14 March 2025

Re: MODIFICATION 3 TO SSD-44034342 – Landscape Architectural Advice for Integrated Mental Health Complex

Site Image has undertaken updates to the following landscape documentation reflecting the following architectural changes

DRAWING TITLE  
**LANDSCAPE PLAN  
LEVEL 6**

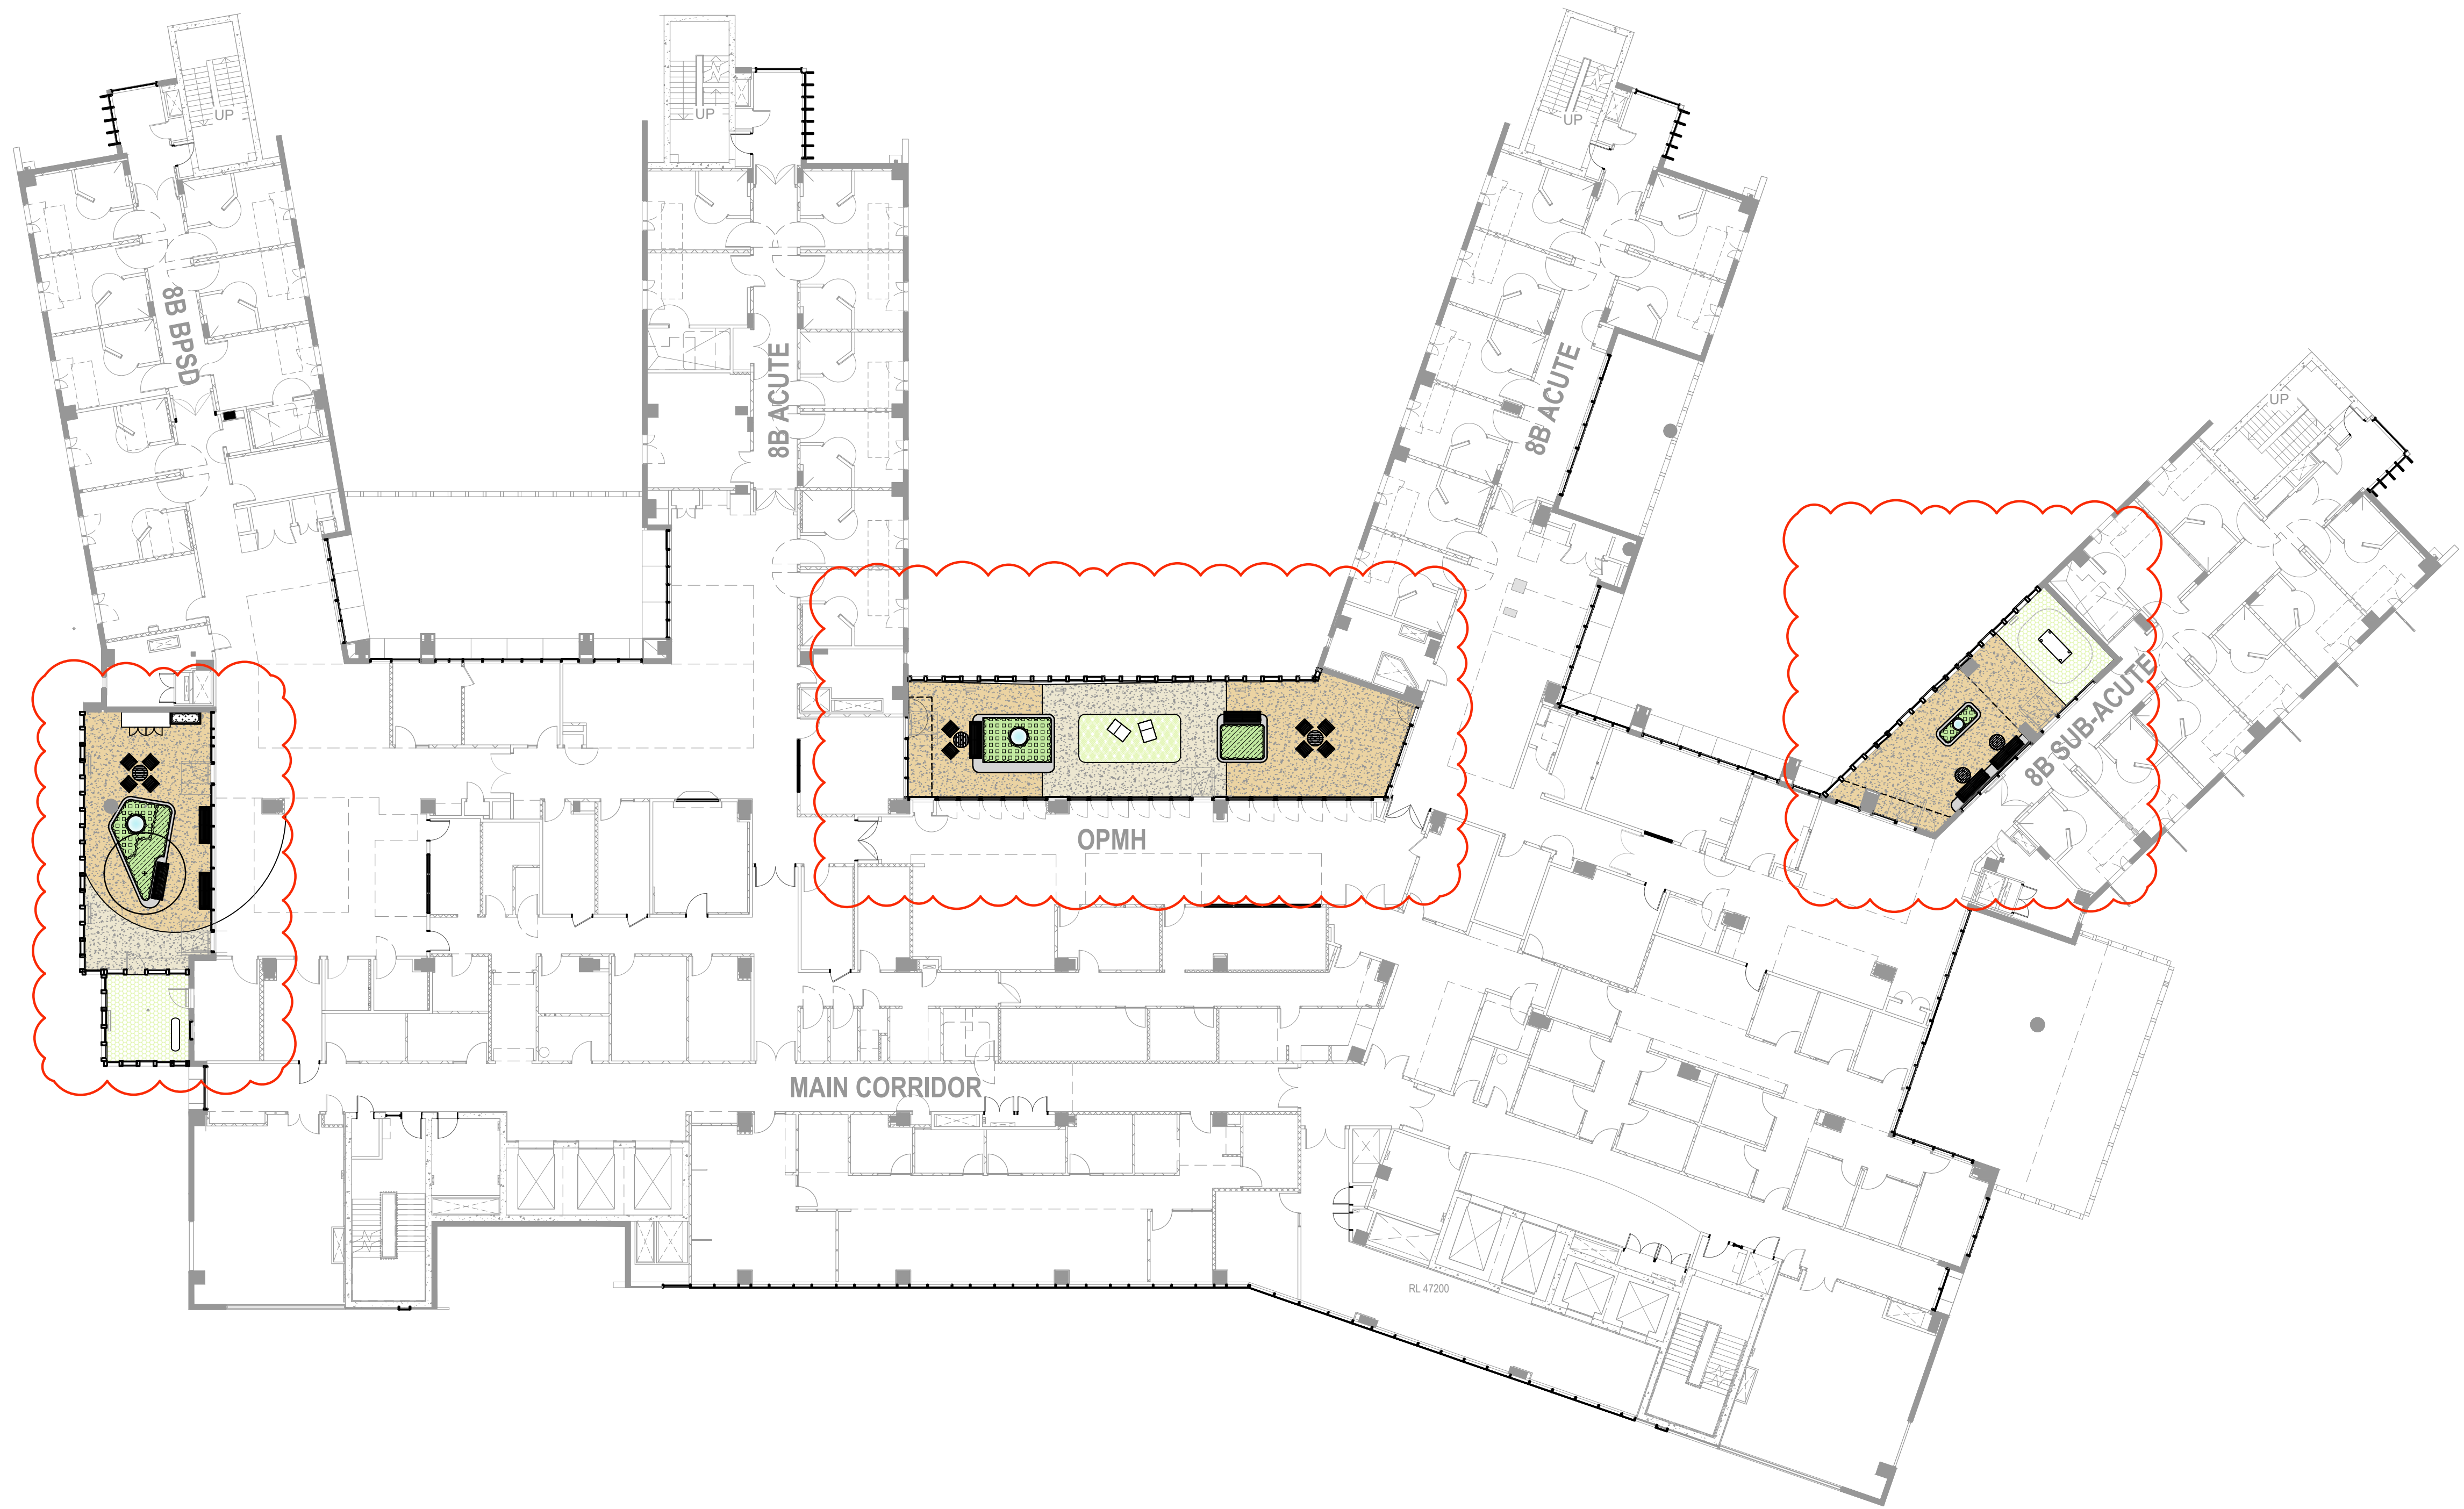
IMHC_LS_DG_0150 Landscape Plan Level 5	Planter size modified, 2 bench seats deleted BBQ deleted, planter reduced and 3 cafe tables deleted. BBQ deleted, planter reduced, 1 x table and chair set deleted.	6
IMHC_LS_DG_0160 Landscape Plan Level 6	BBQ Deleted BBQ deleted, planter reduced Courtyard relocated, pot deleted BBQ deleted, planter and seating wall reduced, Artificial turf size reduced	7
IMHC_LS_DG_0170 Landscape Plan Level 7	Pot deleted Furniture relocated, 1 cafe seating deleted, planter size modified 2 bench seats deleted, planter reduced, BBQ deleted, 1 table deleted 2 bench seats deleted, planter reduced, BBQ deleted, 1 table deleted	7
IMHC_LS_DG_0180 Landscape Plan Level 8	BBQ deleted, planter reduced, pots deleted. Pot deleted from de-escalation courtyard BBQ deleted, planter size modified, bench seats added, cafe seating added	6
IMHC_LS_DG_0190 Landscape Plan Level 9	Artificial turf reduced, bench seats added Layout updated, planter beds modified, table and seats added	6
